Re: Slim Chickens
8240 Montgomery Blvd. NE
30-Day Temporary Certificate of Occupancy
Transportation Development Final Inspection
Engineer's Stamp dated 07-05-22 (G19-D004E)
Certification dated 11-13-23

Based upon the information provided in your submittal received 11-13-23, Transportation Development has no objection to a 30-day Temporary Certificate of Occupancy based. This letter serves as a "green tag" from Transportation Development for a 30-day Temporary Certificate of Occupancy to be issued by the Building and Safety Division.

Prior to the issuance of a permanent Certificate of Occupancy, the following items must be addressed:

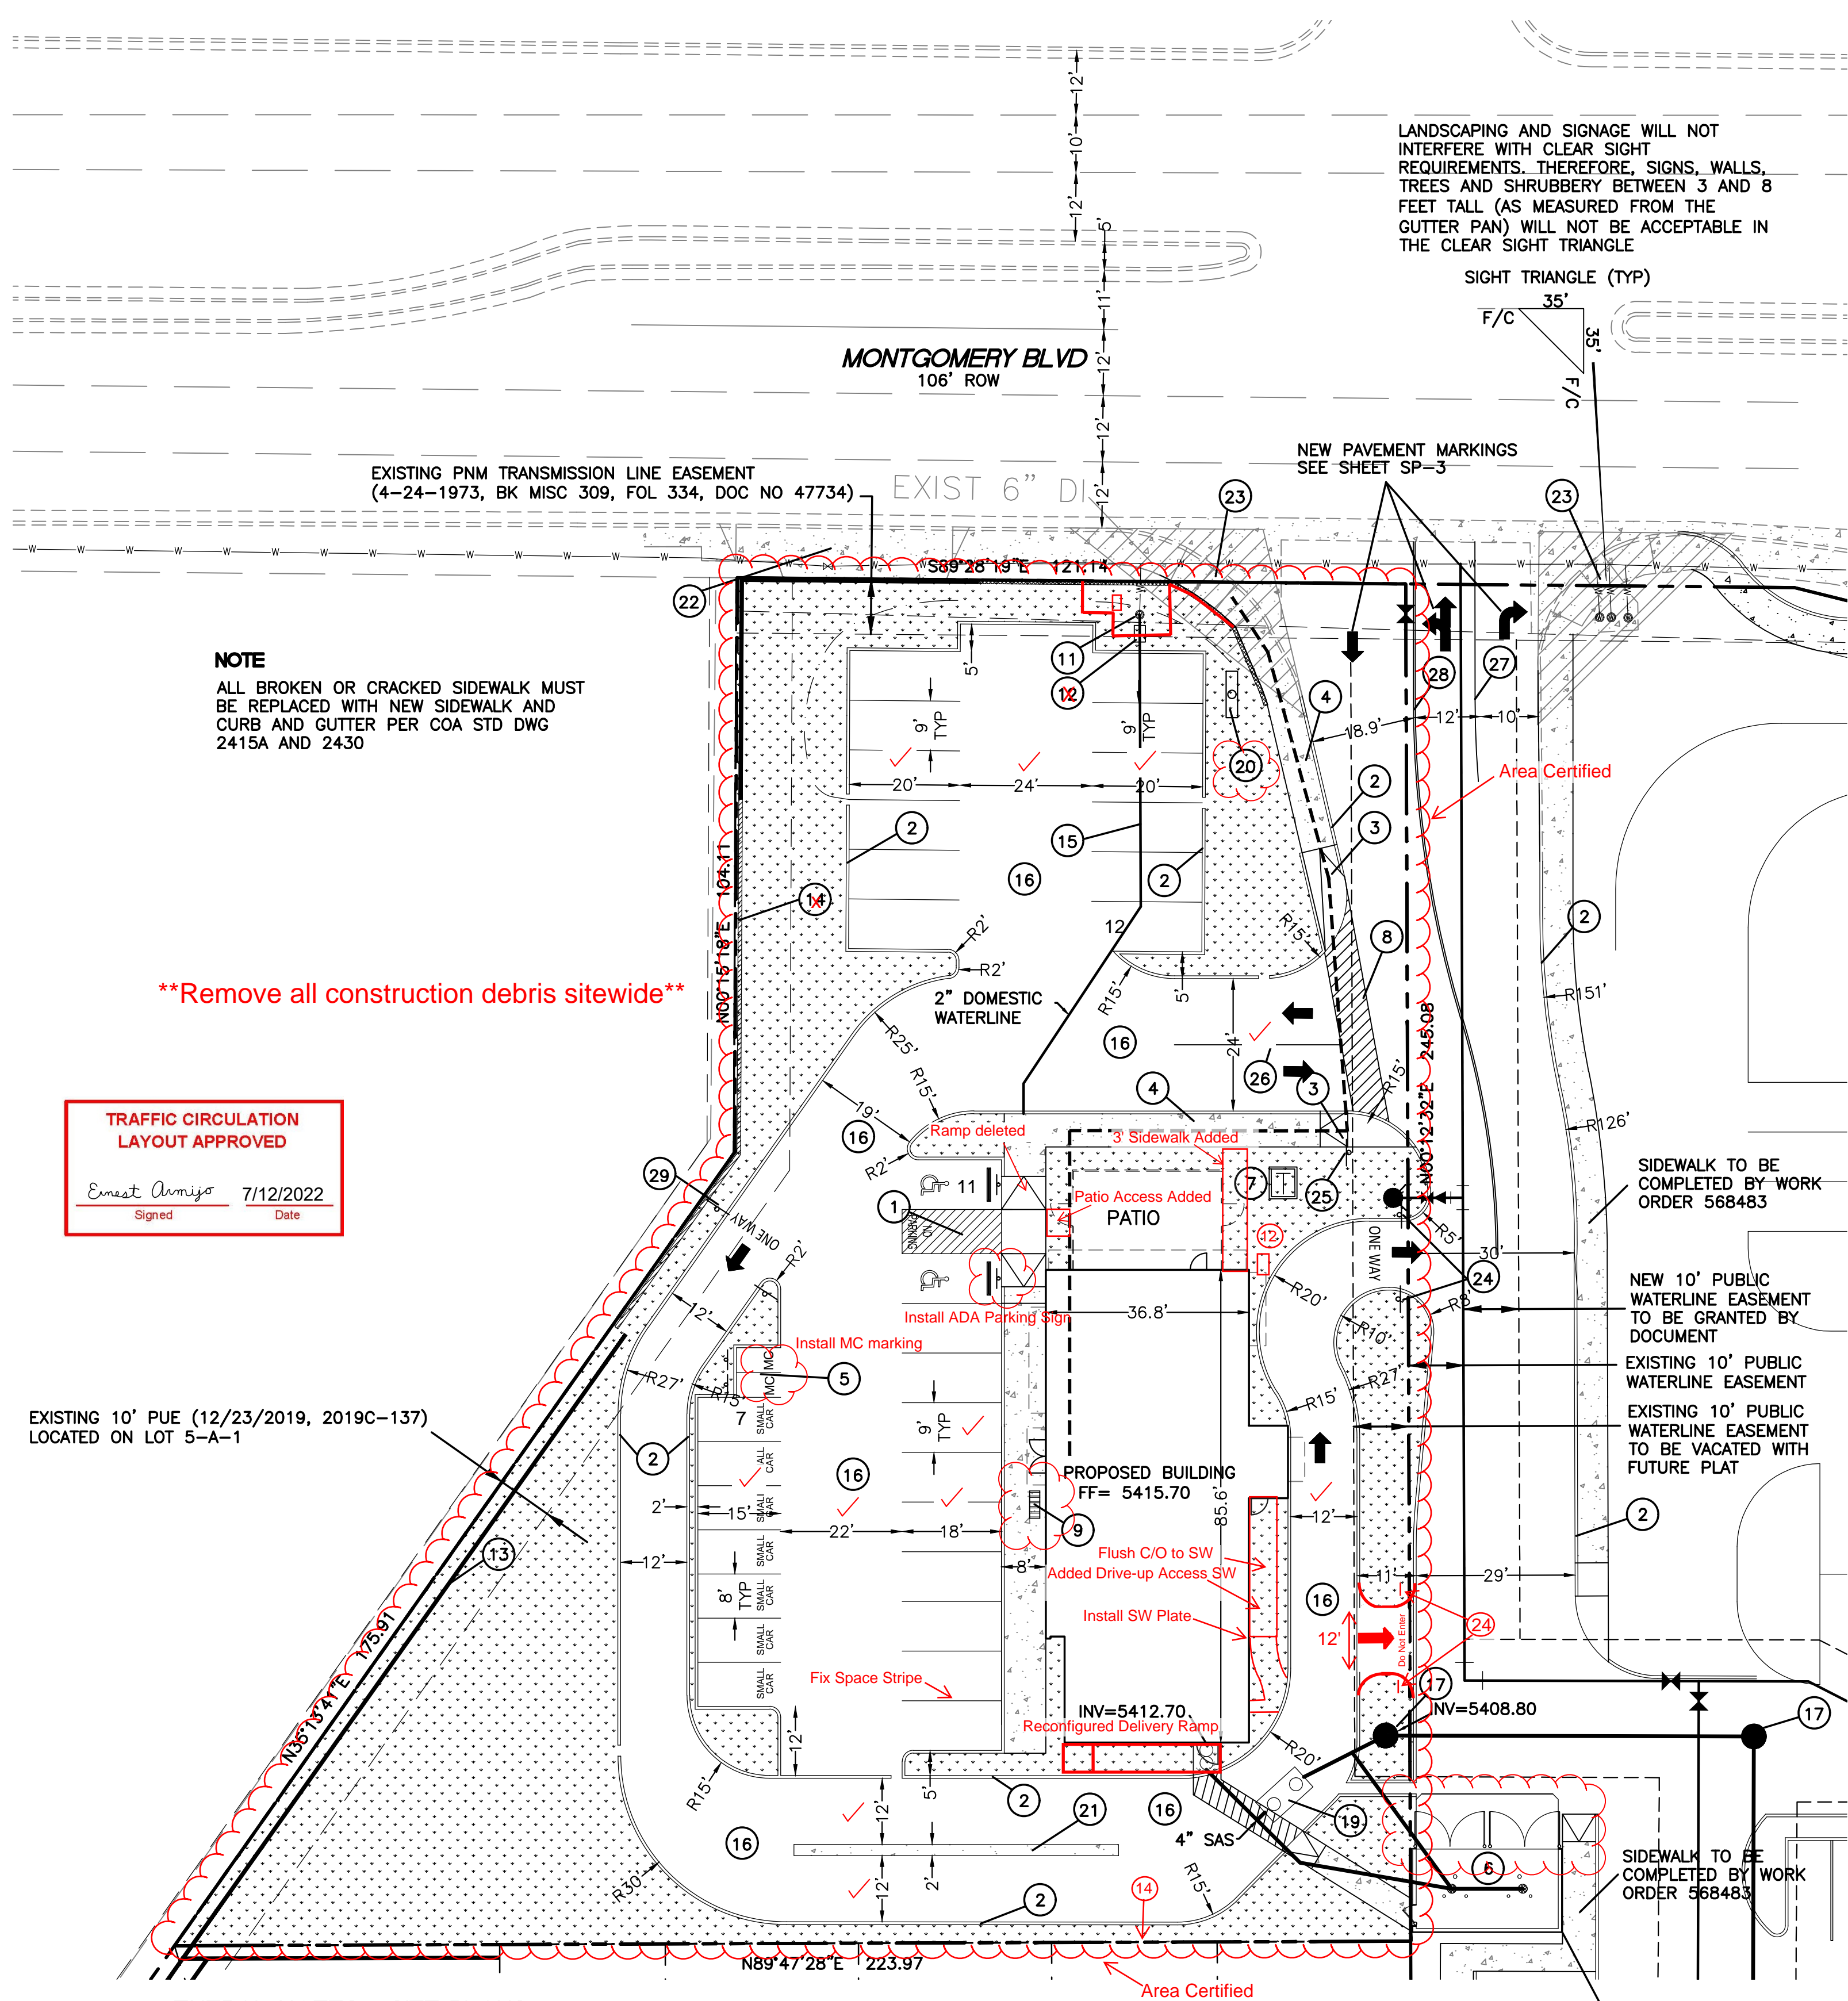
- Please fix the concrete cracked on the northeast side of the site access.

- Per site visit, there was a new egress within the drive-thru area. Please red-mark the approved site plan to represent the as-built situation. And “DO NOT ENTER” signs and pavement marking must be provided.

- Provide “MC” pavement marking.
- Remove the fence and construction debris from the site.
- As a condition of releasing the final CO, please provide a copy of modified approved plat, showing the 6 ft. wide public sidewalk easement on the east side of the property.
